Item No. **Report of the Interim Director of Planning, Regeneration & Public Realm**

Address: 1372 UXBRIDGE ROAD HILLINGDON

Development: Variation of Condition 2 (approved plans) of planning permission ref. 5625/APP/2019/917 dated 10-05-2019 'Three storey building for use as 3 x studio flats and 2 x 1-bed self contained flats, installation of 2 x vehicular crossovers and demolition of existing two storey building' to enlarge two studio flats.

LBH Ref Nos: 5625/APP/2023/937

SCALE 1:50 @A1	DRAWING No.	REV.
DATE MAR '19		
DRAWN LK	4971-9	C

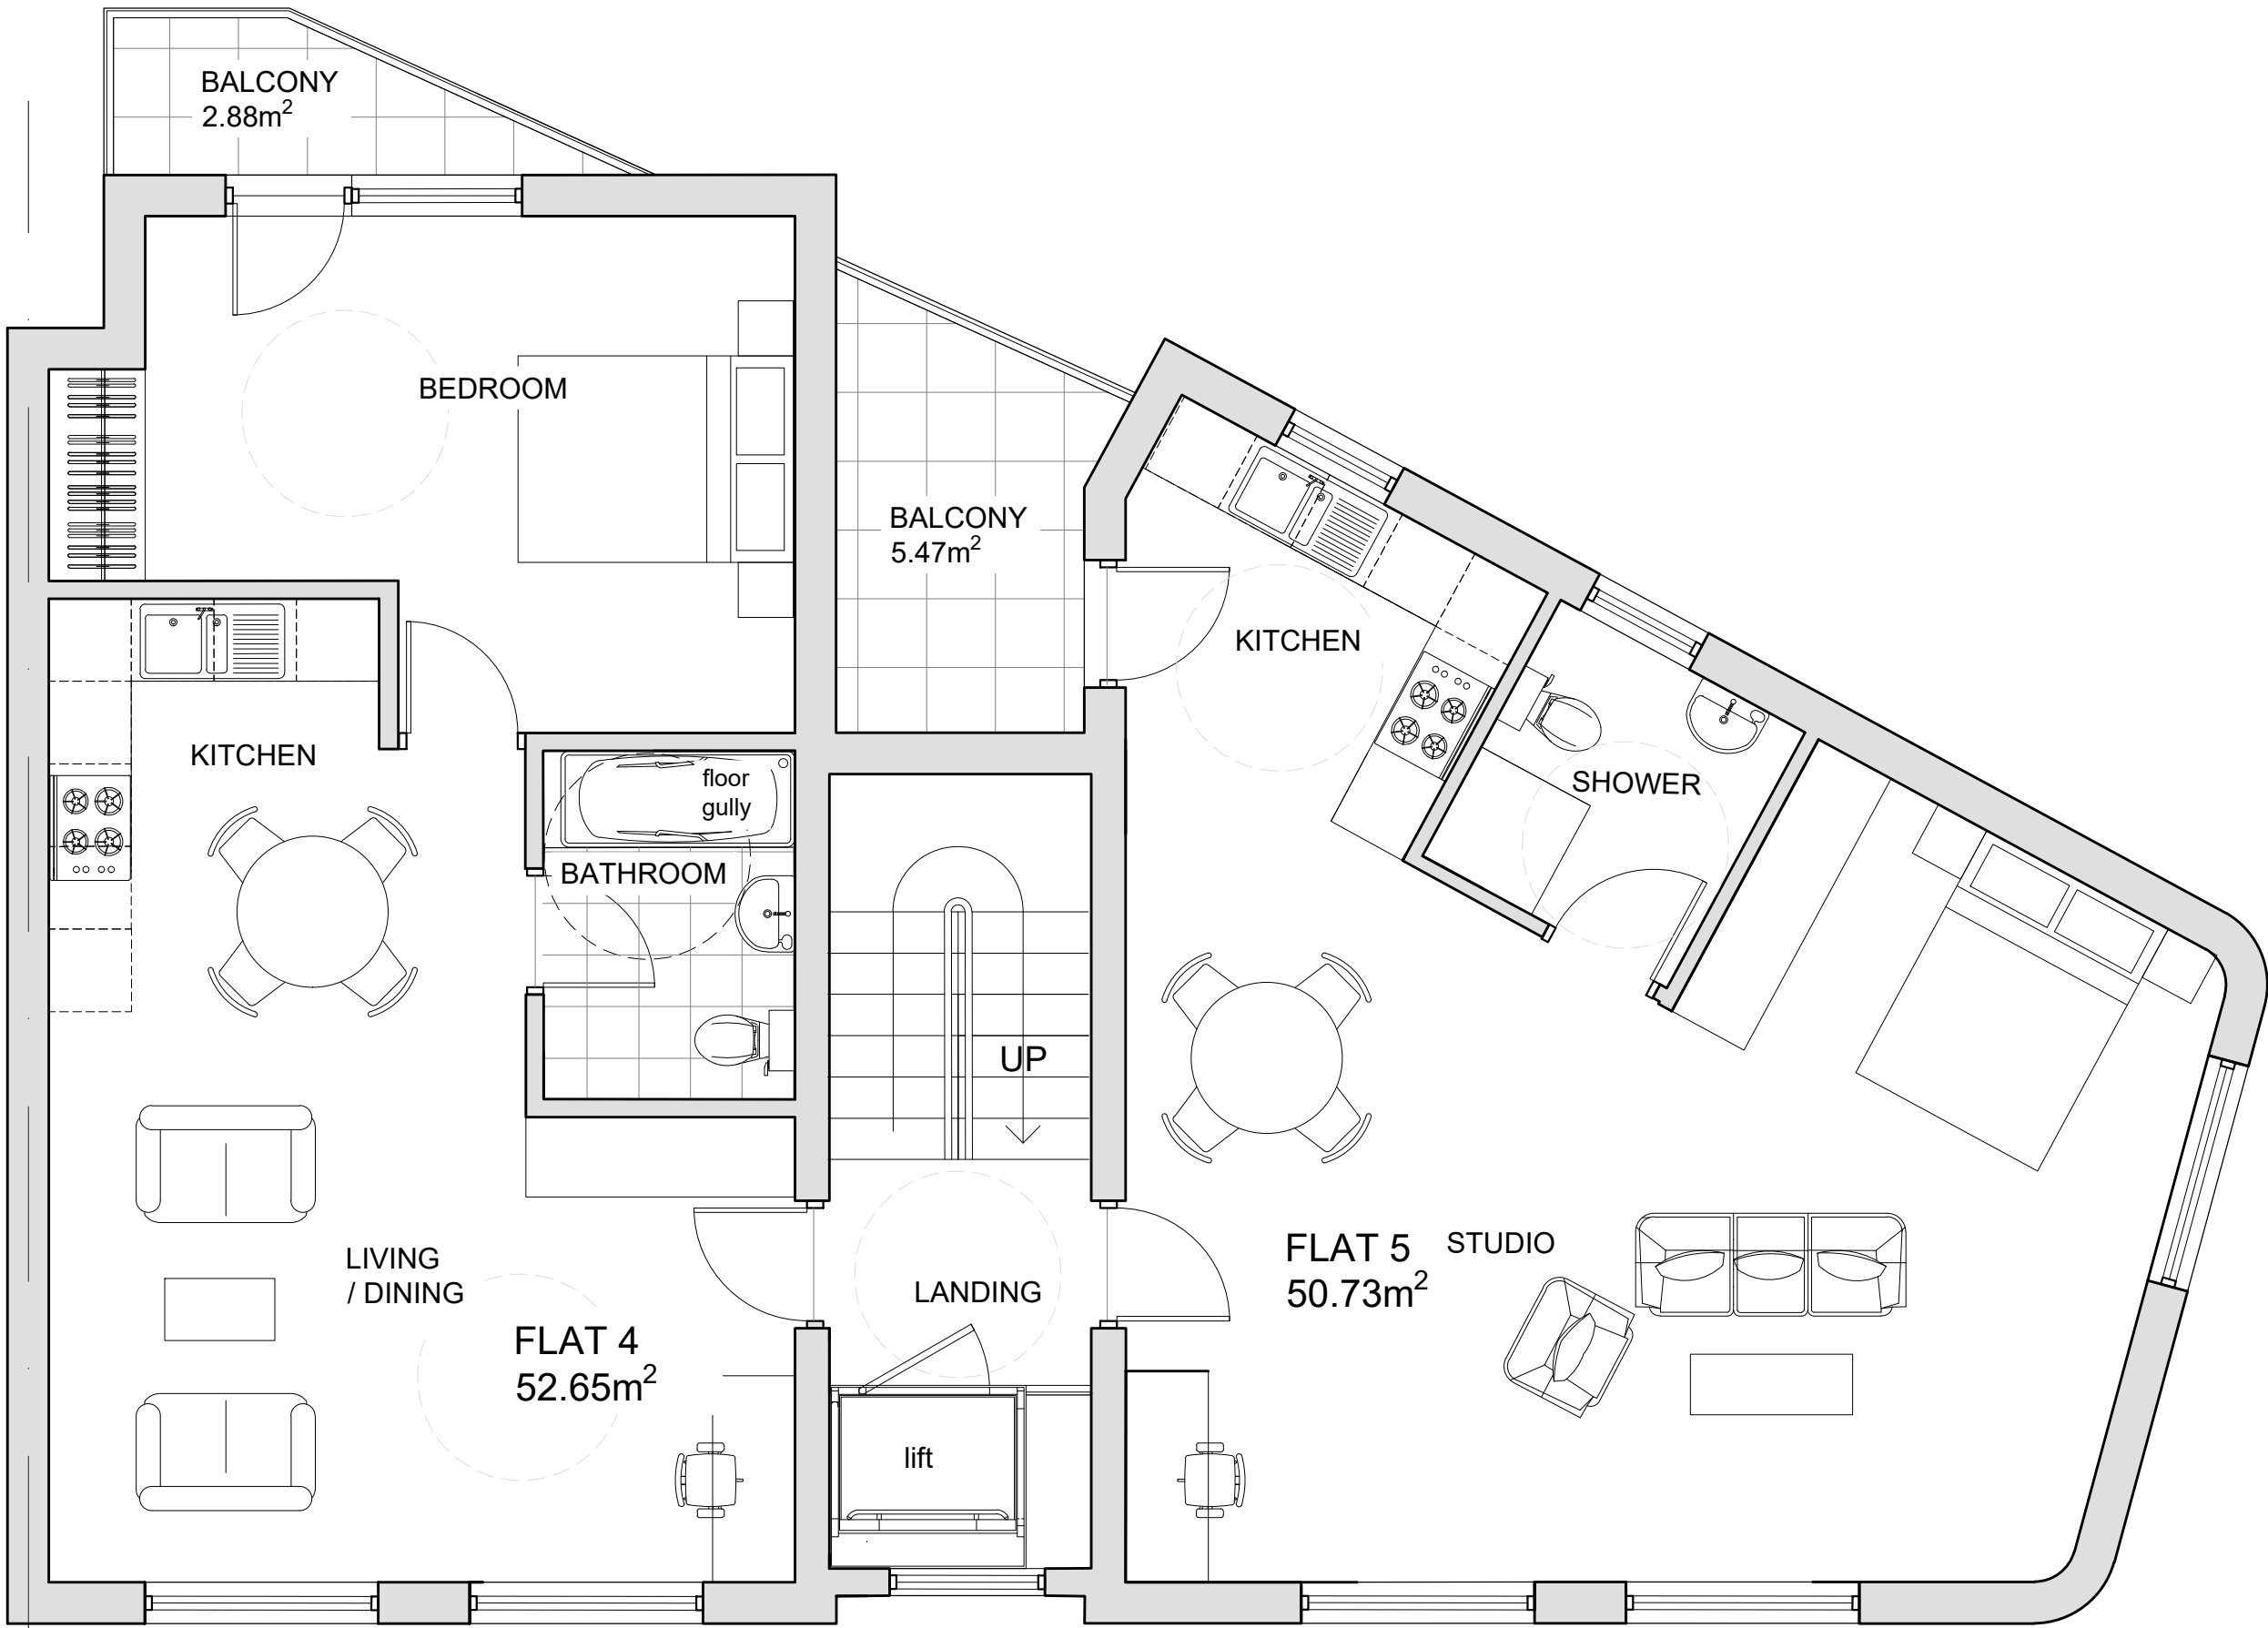
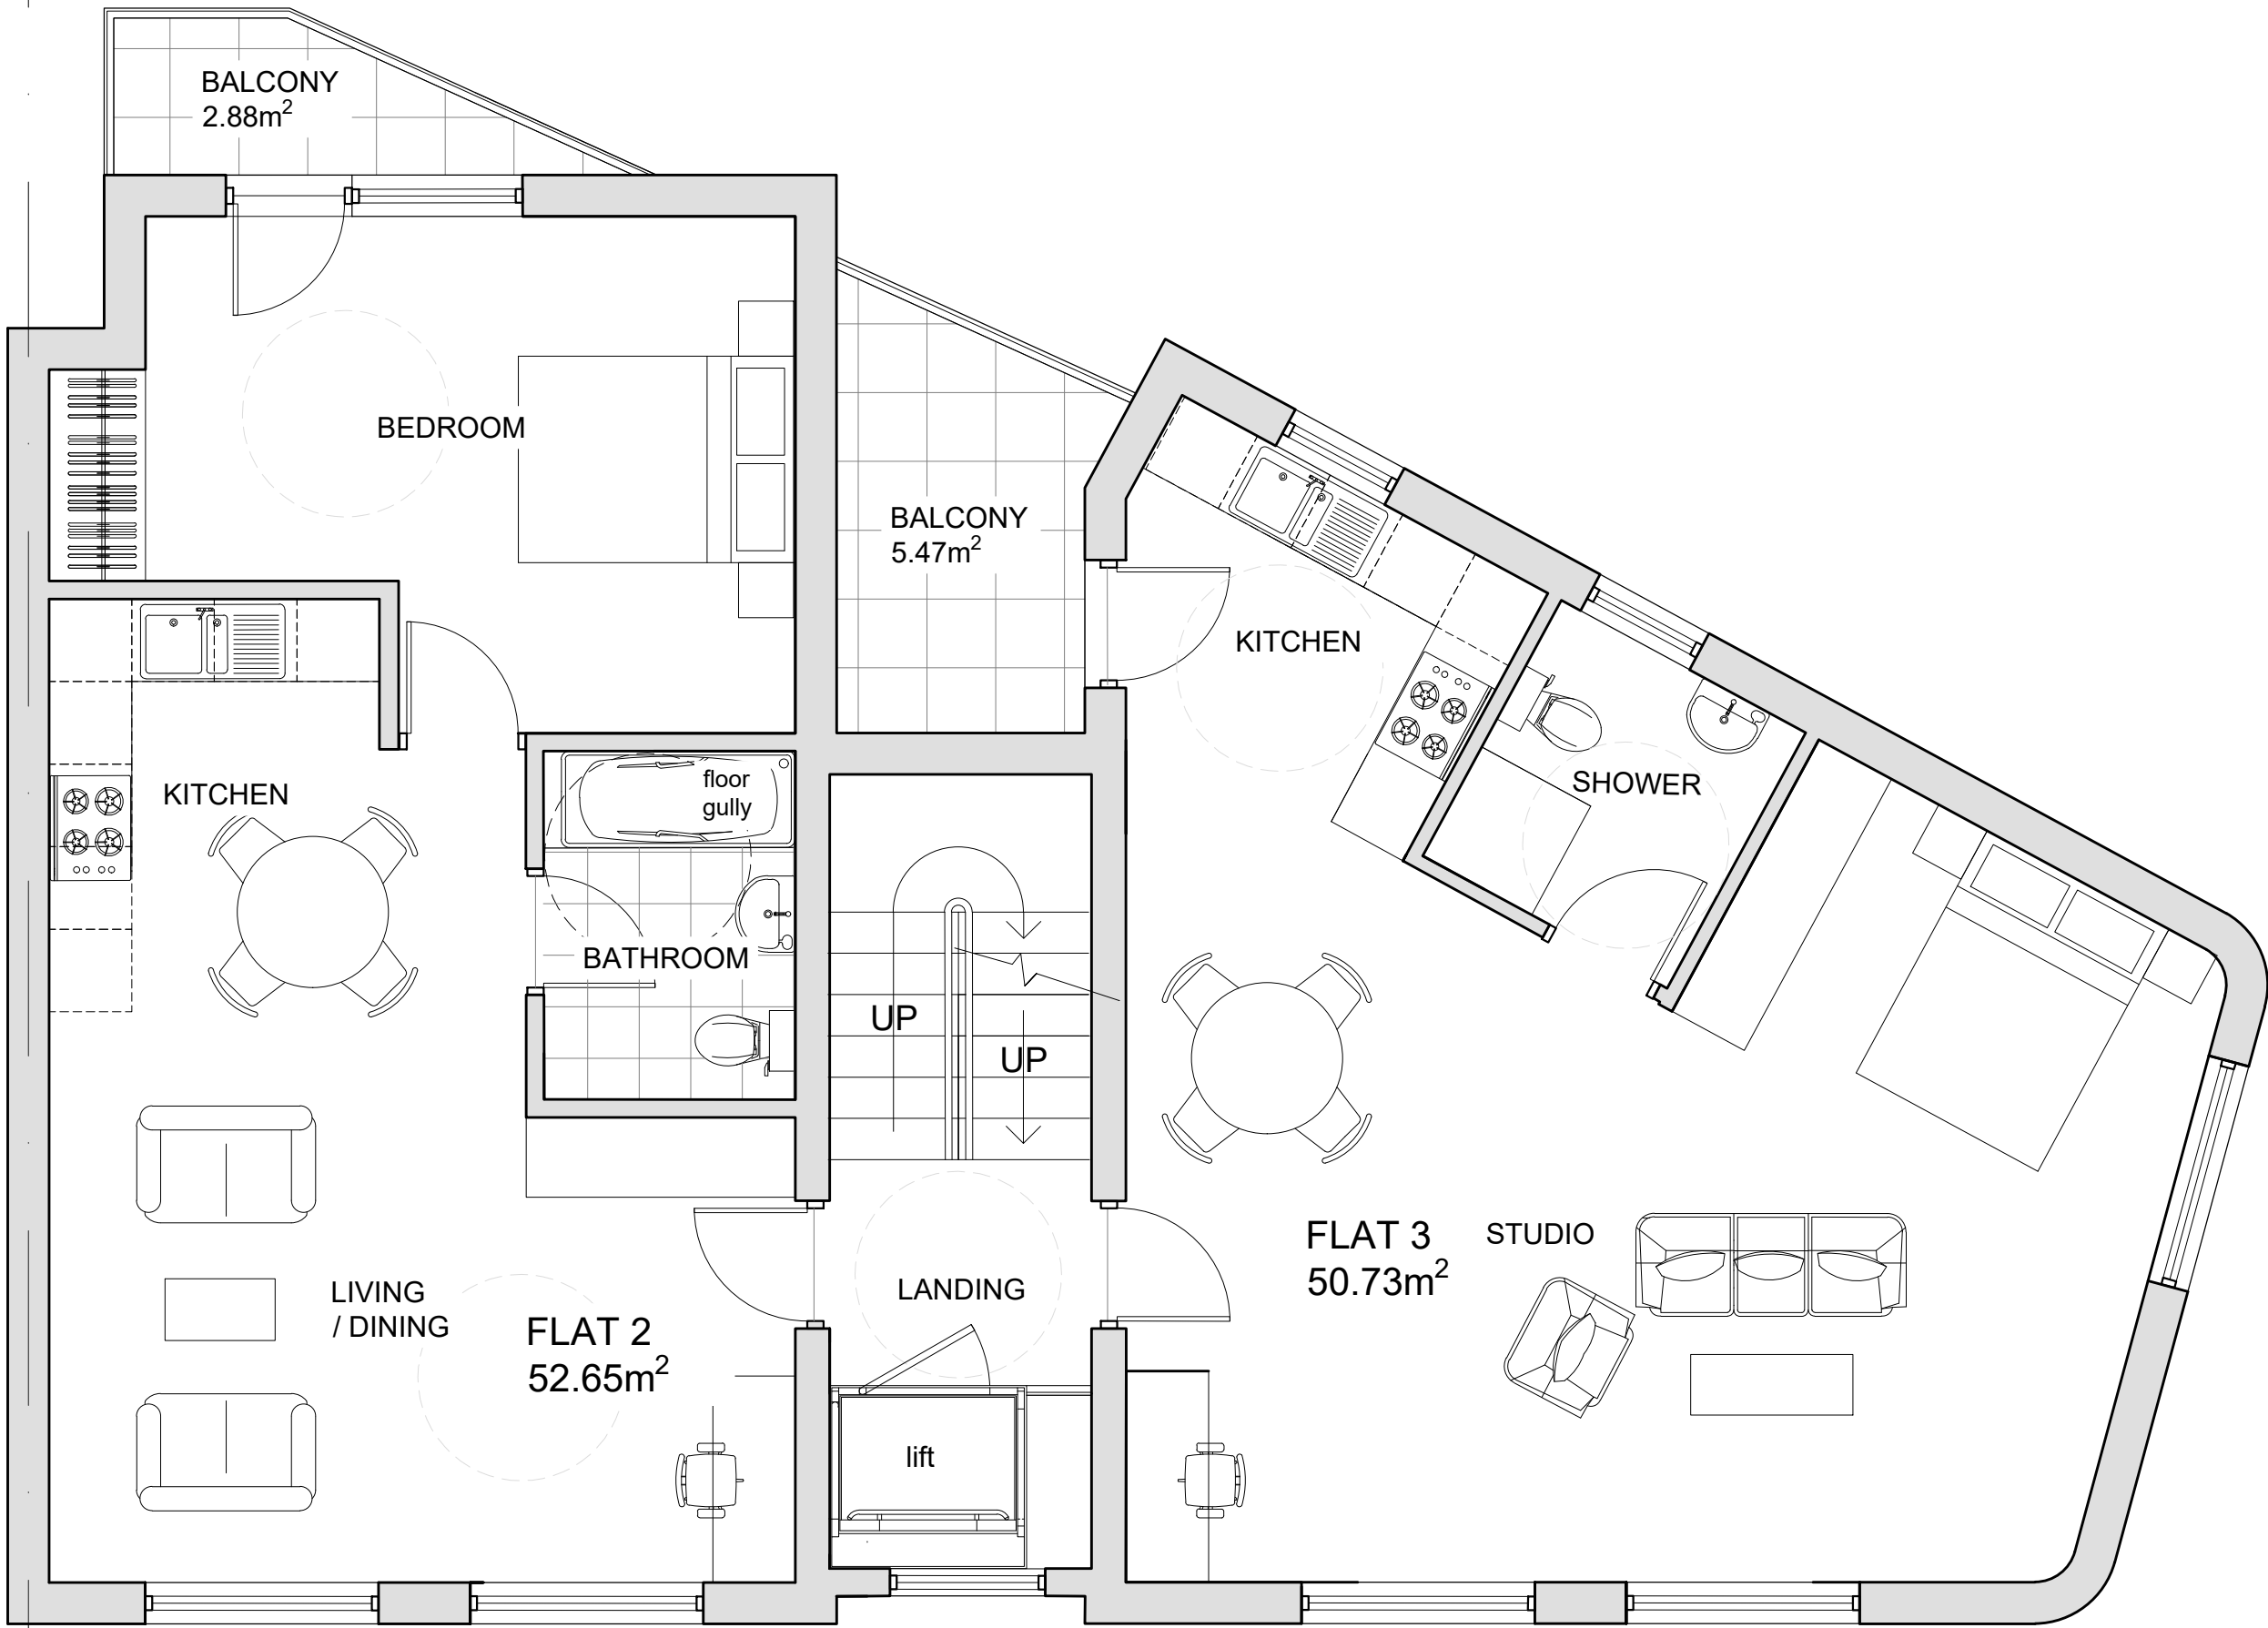
The proposal, by reason of its forward projection towards Hewens Road and the increase in the undercroft, in close proximity to the site boundaries, would result in a cramped and incongruous form of development which would detract from the character and appearance of the surrounding area and the visual amenities of the street scene. The proposal is therefore contrary to Policy BE1 of the Hillingdon Local Plan: Part One - Strategic Policies (November 2012), Policies DMHB 11, DMHD 12 and DMHD 1 of the Hillingdon Local Plan Part Two - Development Management Policies (2020).

There are a diverse range of styles, designs and materials in the make up of the existing properties within the street scene. The application site is in a particularly prominent and visible location at the end of the a row of properties of similar scale and two-storeys on the corner of Uxbridge Road with Hewens Avenue. The submitted streetscene indicates the approved but not implemented three storey building at number 1380 Uxbridge Road under application reference 71035/APP/2016/4048 for the erection of a three storey building to provide 5 x 2-bed self-contained flats with associated parking, cycle and waste storage. The existing building is not considered to be of any architectural merit and its loss and replacement with a 3 storey building of similar scale to that approved at the nearby site at 1380 is considered acceptable. The proposed amended building would increase the overall bulk of the building towards Hewens Road. The visual impact would appear acceptable from Uxbridge Road, but the additional massing towards Hewens Road, with the additional massing making the upper floors appear top heavy and would be an incongruous alteration to the approved building, of particular concern in this prominent corner location. The undercroft as extended would be a dark and uninviting space, detrimental to the street scene.

The original approval included balcony provision for all flats. This provision, given the proximity to the nearby public park, was considered acceptable. In this case, the proposal would result in a re-arrangement of balconies with the 2 enlarged studios being provided with inverted balconies. All units would achieve a satisfactory outdoor amenity space provision.
